HIGHWAY AND LEAD LOCAL FLOOD AUTHORITY RESPONSE TO CONSULTATION ON THE FOLLOWING DEVELOPMENT PROPOSAL

Application number: H12-1121-25

Proposal: Proposed vehicular access

Location: Villa Farm, Lutton Garnsgate, Long Sutton, Spalding, PE12 9JP

SITE PLAN - PROPOSED - 1:250

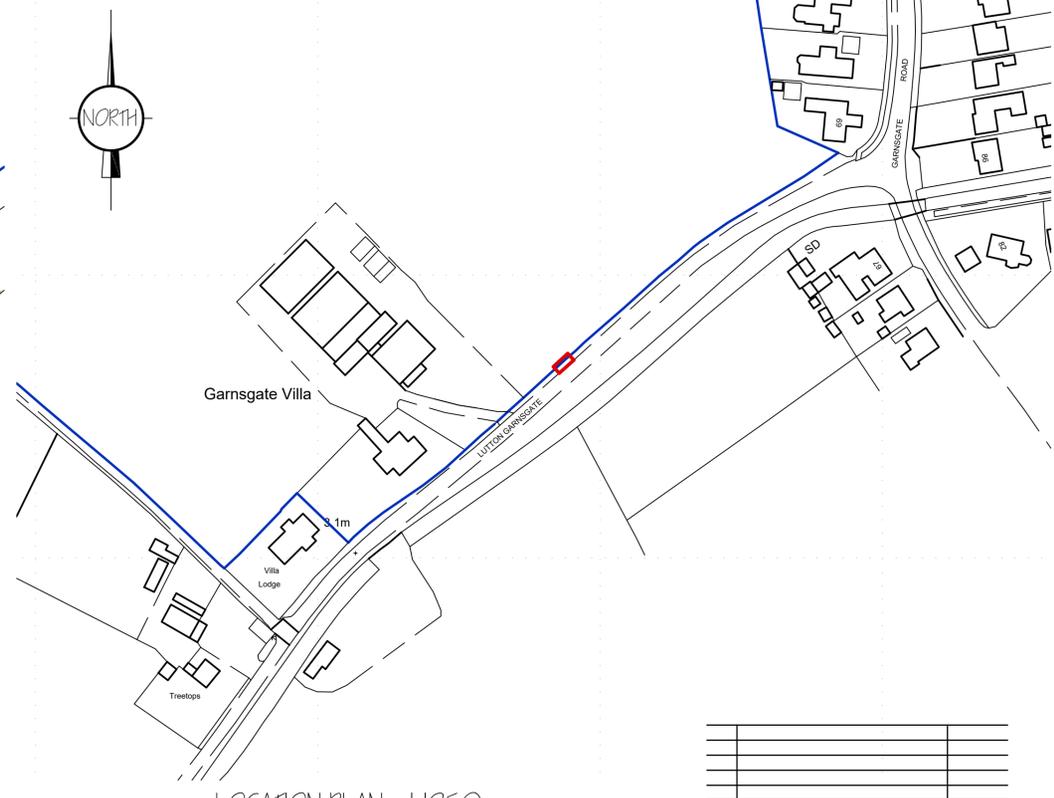
Proposed vehicular access – Visibility has been demonstrated in accordance with Manual for Streets for a 60mph road. In order to maintain the visibility a condition is required to keep the visibility splay clear of obstructions. The access will be constructed to Lincolnshire County Council specification as detailed on the proposed site plan. The proposal will not have an adverse impact on the public highway.

Before the access is brought into use all obstructions exceeding 0.6 metres high shall be cleared from the land within the visibility splays illustrated on drawing number 4382-25-05A dated February 2026 and thereafter, the visibility splays shall be kept free of obstructions exceeding 0.6 metres in height.
